CITY OF ALBUQUERQUE

**Re: McMahon Market Place, Building 9A
5750 McMahon Marketplace NE,
30-Day Temporary Certificate of Occupancy
Transportation Development Final Inspection
Engineer's/Architect's Stamp dated 10-25-19 (A11D011I)
Certification dated 11-5-20**

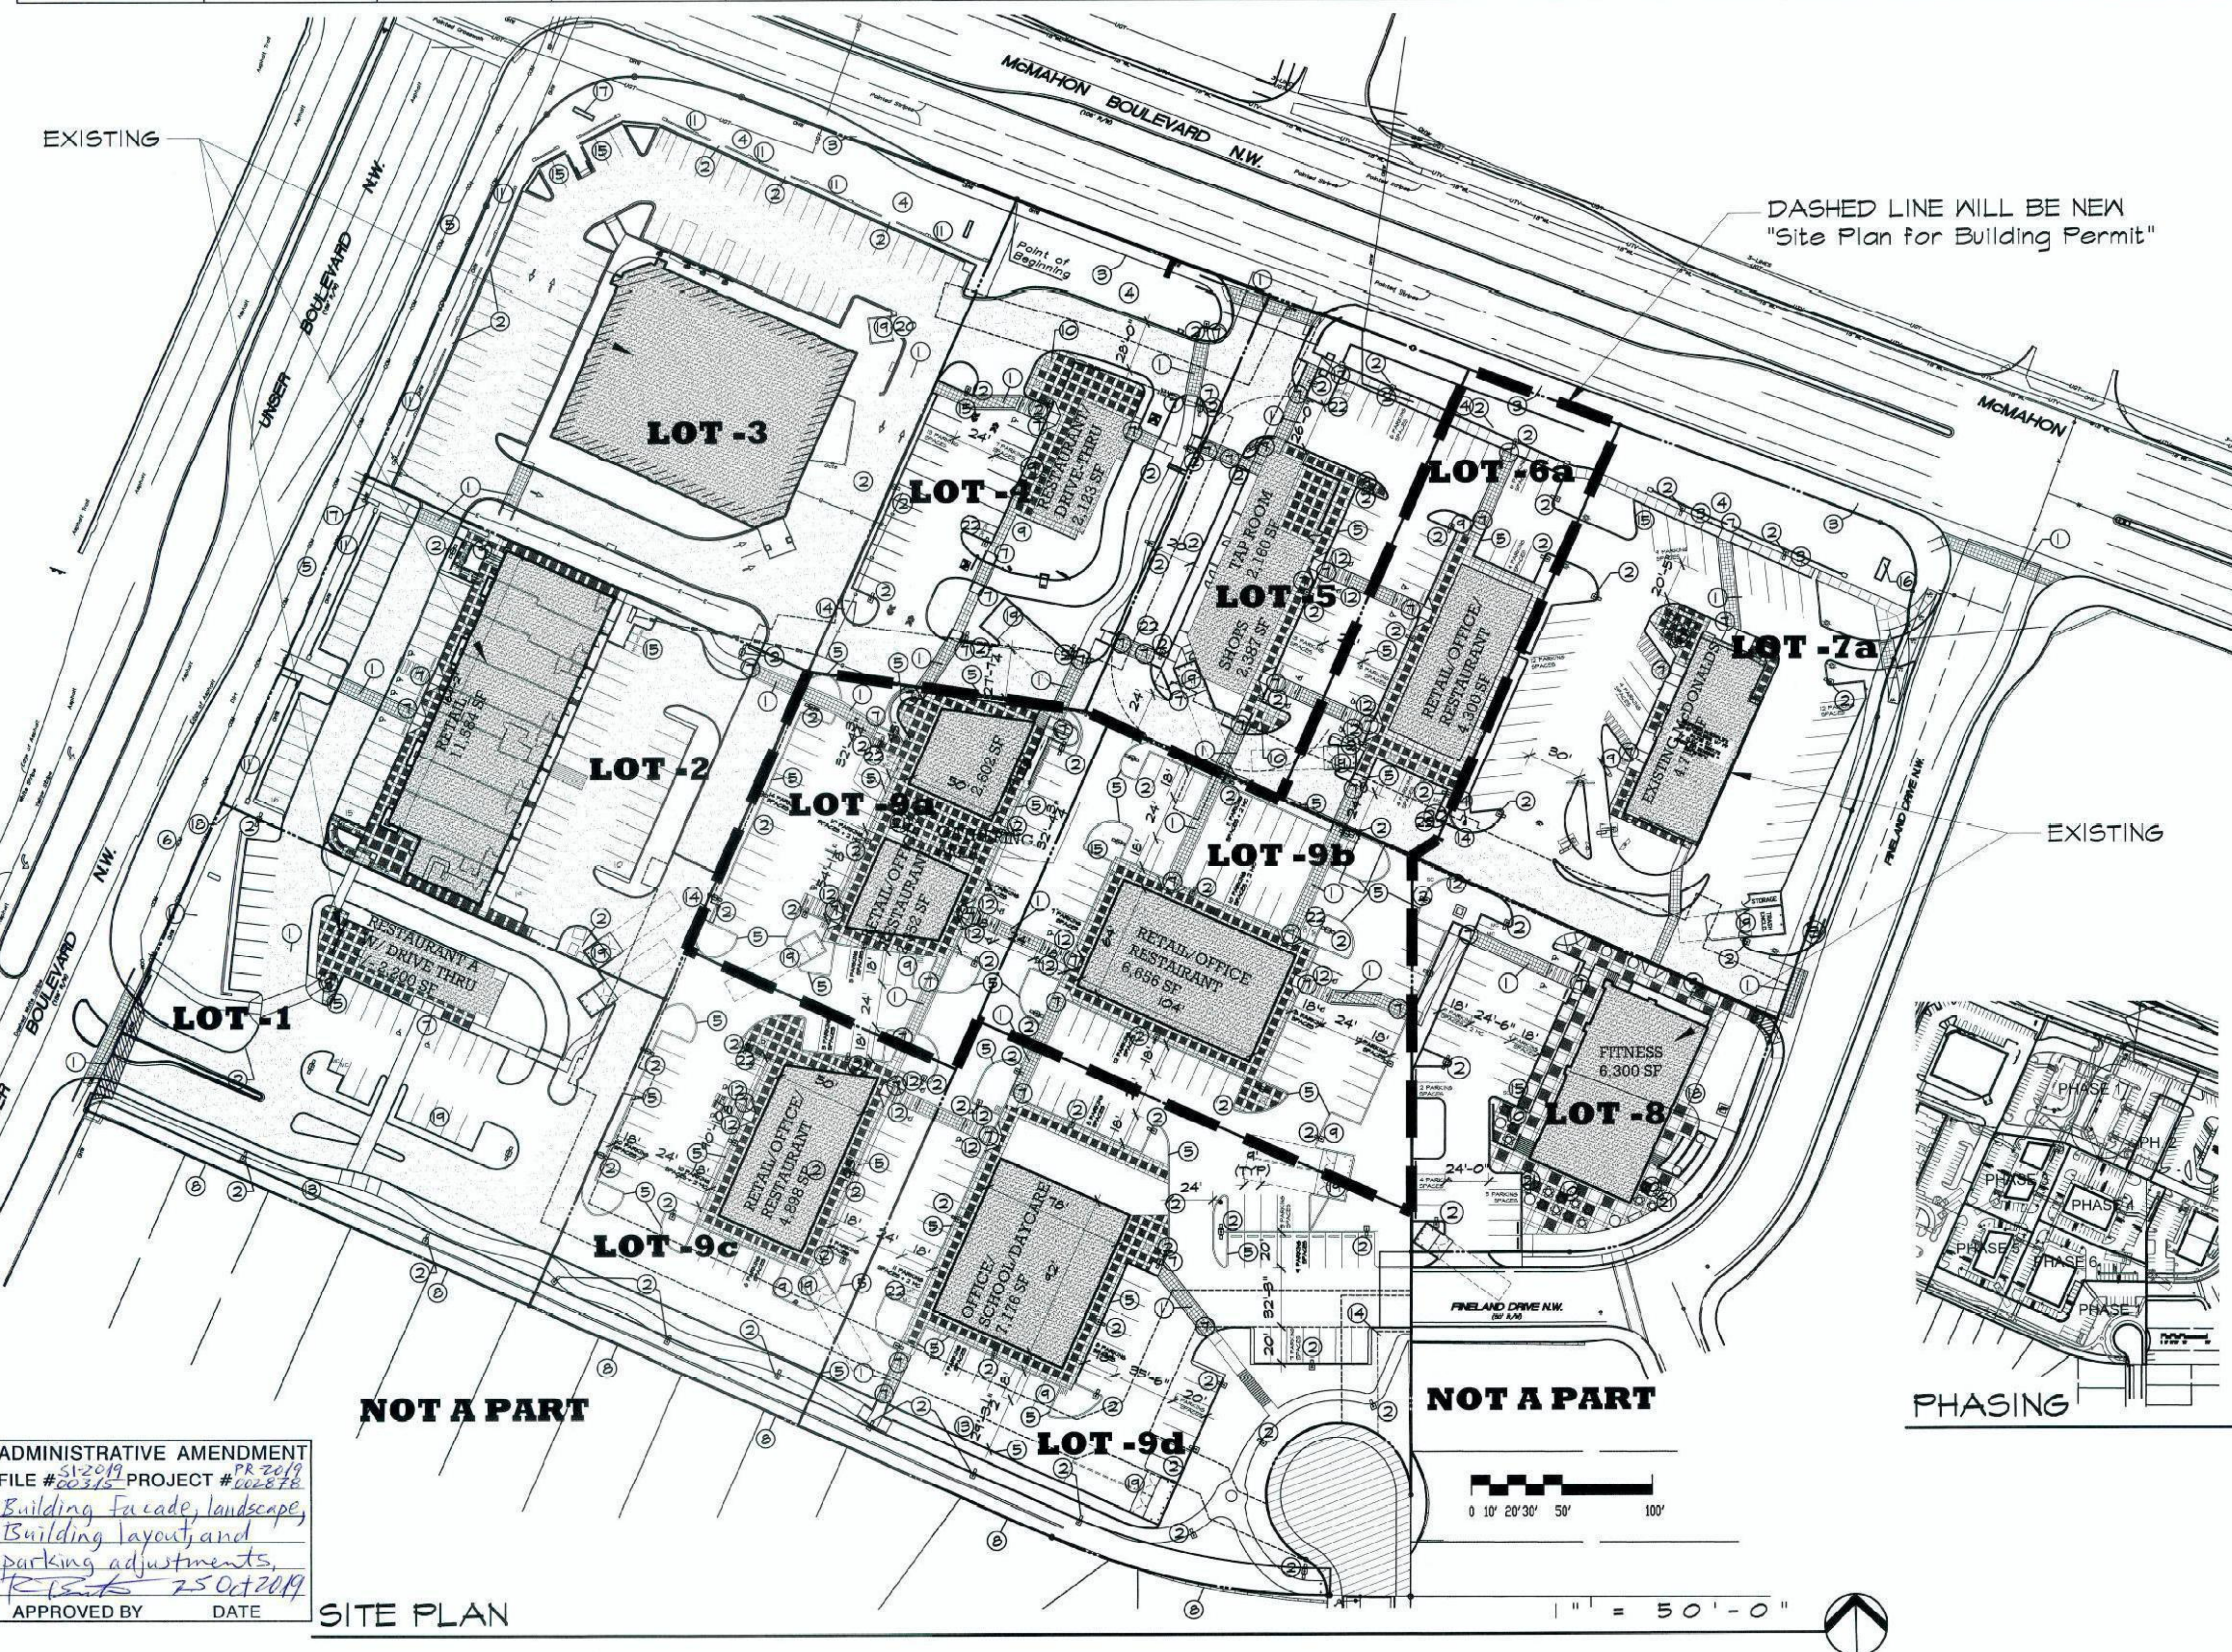
- Please add No Parking to ADA access aisle. The ADA access aisle shall have the words **"NO PARKING"** in capital letters, each of which shall be at least one foot high and at least two inches wide, placed at the rear of the parking space so as to be close to where an adjacent vehicle's rear tire would be placed. (66-1-4.1.B NMSA 1978)
